RE: Unit 3 Land At Salt Box West of Shripney Road Bognor Regis PO22 9NW

Thank you for your correspondence of the 18th of August 2021, advising me of a planning application for Approval of reserved matters following BE/135/18/PL for appearance, landscaping and layout of Unit 3. This application may affect the character & appearance of the Shripney Conservation Area & is in CIL Zone 2 (Zero Rated) as other development at the above location, for which you seek advice from a crime prevention viewpoint

This planning application relates to approval of reserved matters following BE/135/18/PL for appearance, landscaping and layout of Unit 3. Information has also been submitted for part discharge (only for unit 3) of the following outline planning conditions: 5 - External finishes, 6 - Design Code document, 10 - Surface water design, 15 - Foul water design, 20 - Noise report, 21 - Energy strategy, 22 - External lighting design, 29 - Hard and soft landscaping.

Proposed site plan

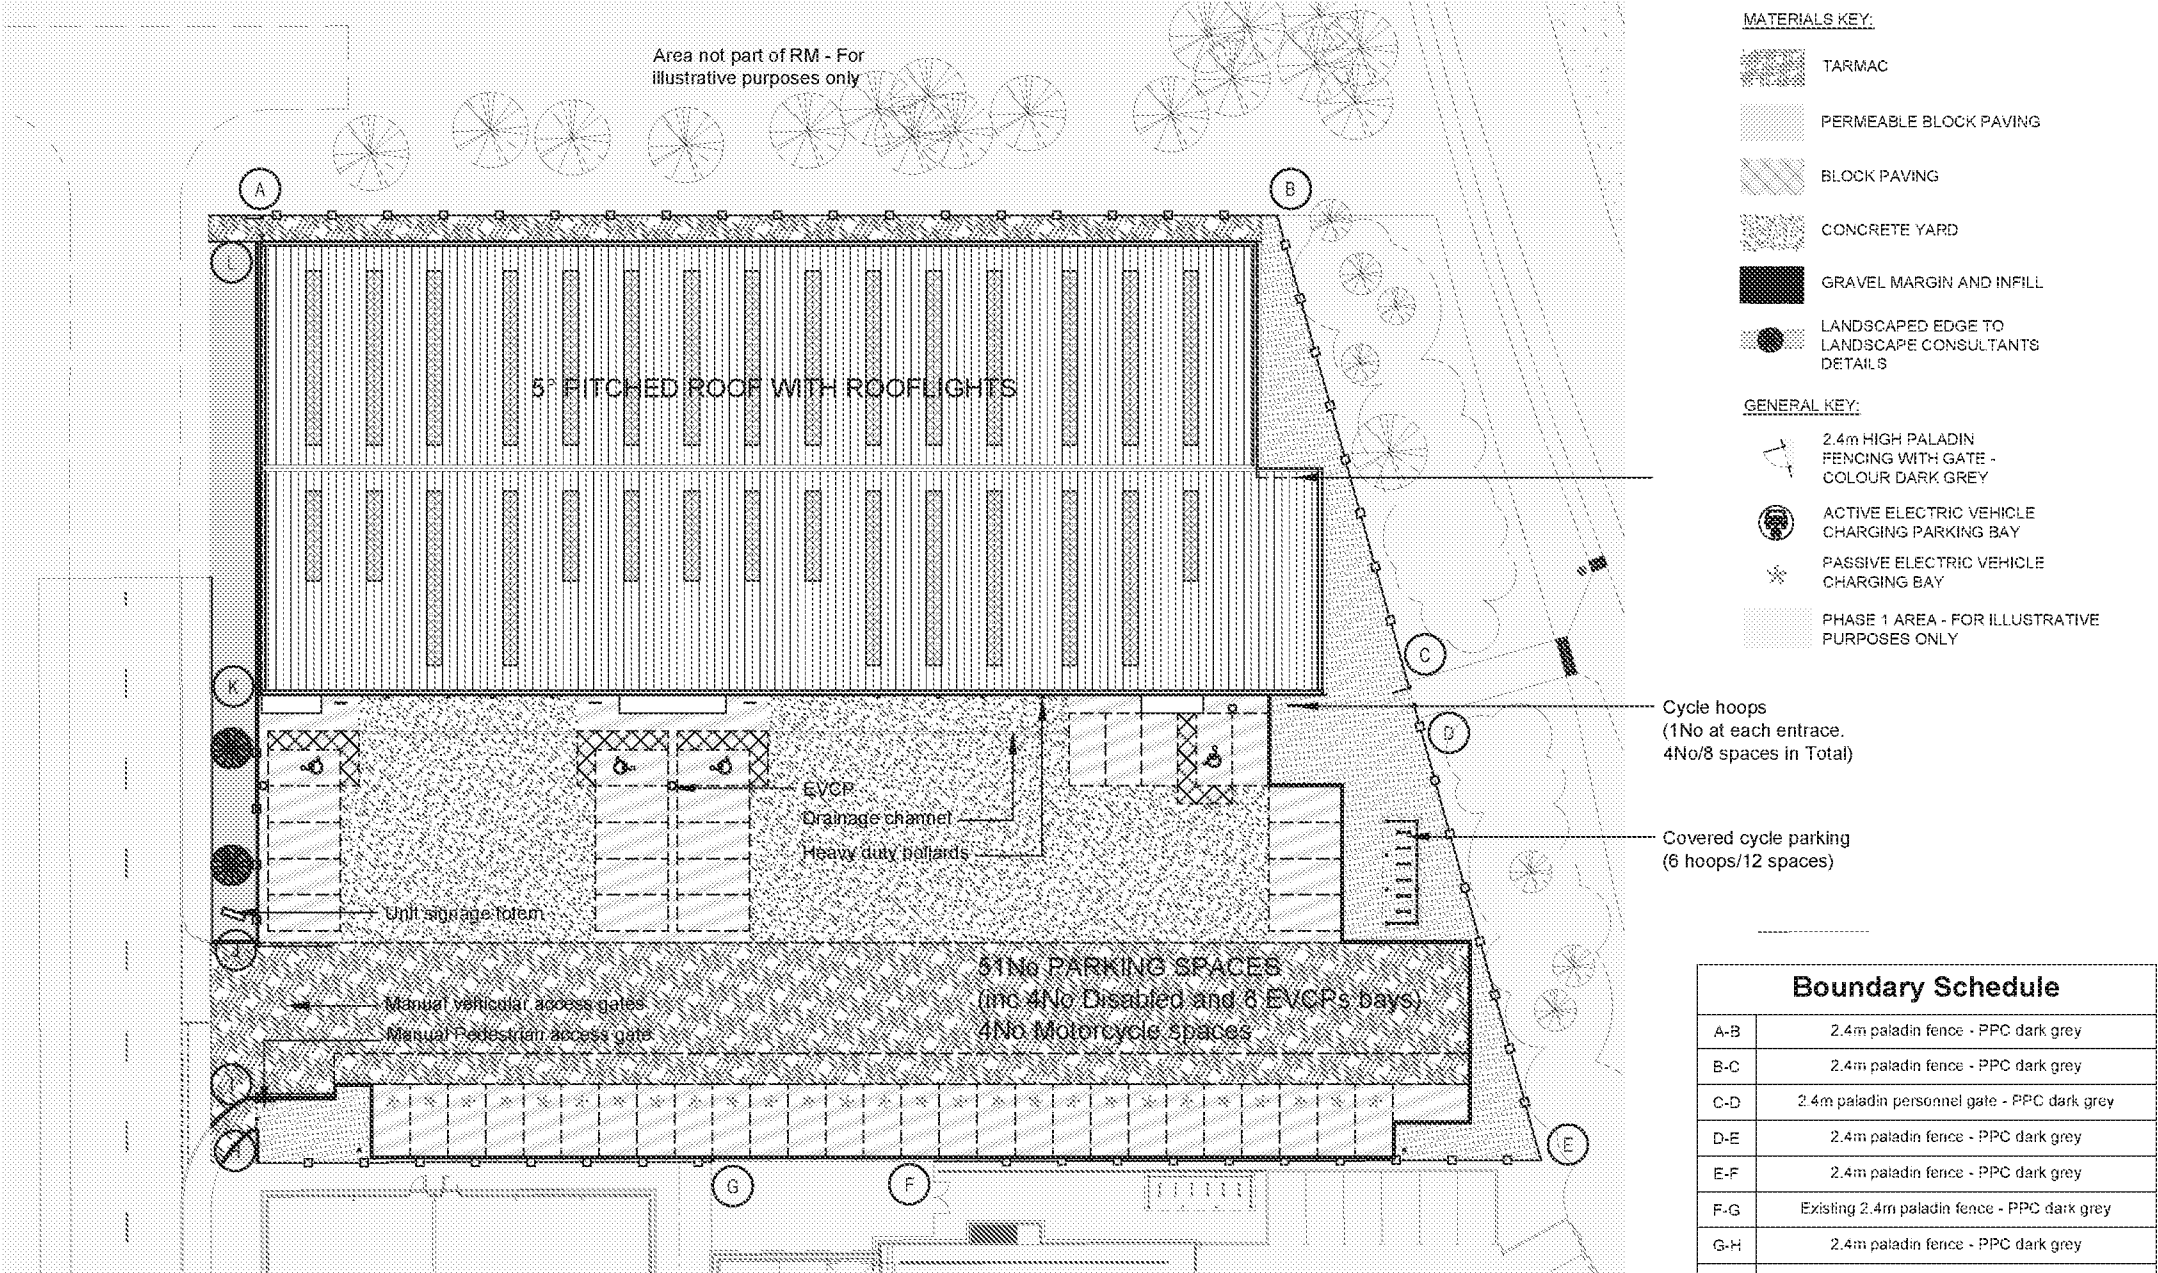
In relation to proposed landscaping and boundary treatments I recommend that ground planting should not be higher than 1 metre with tree canopies no lower than 2 metres. This arrangement provides a window of observation throughout the area.

I was very pleased to note that the plot is being enclosed by the application of paladin as a site boundary fence.
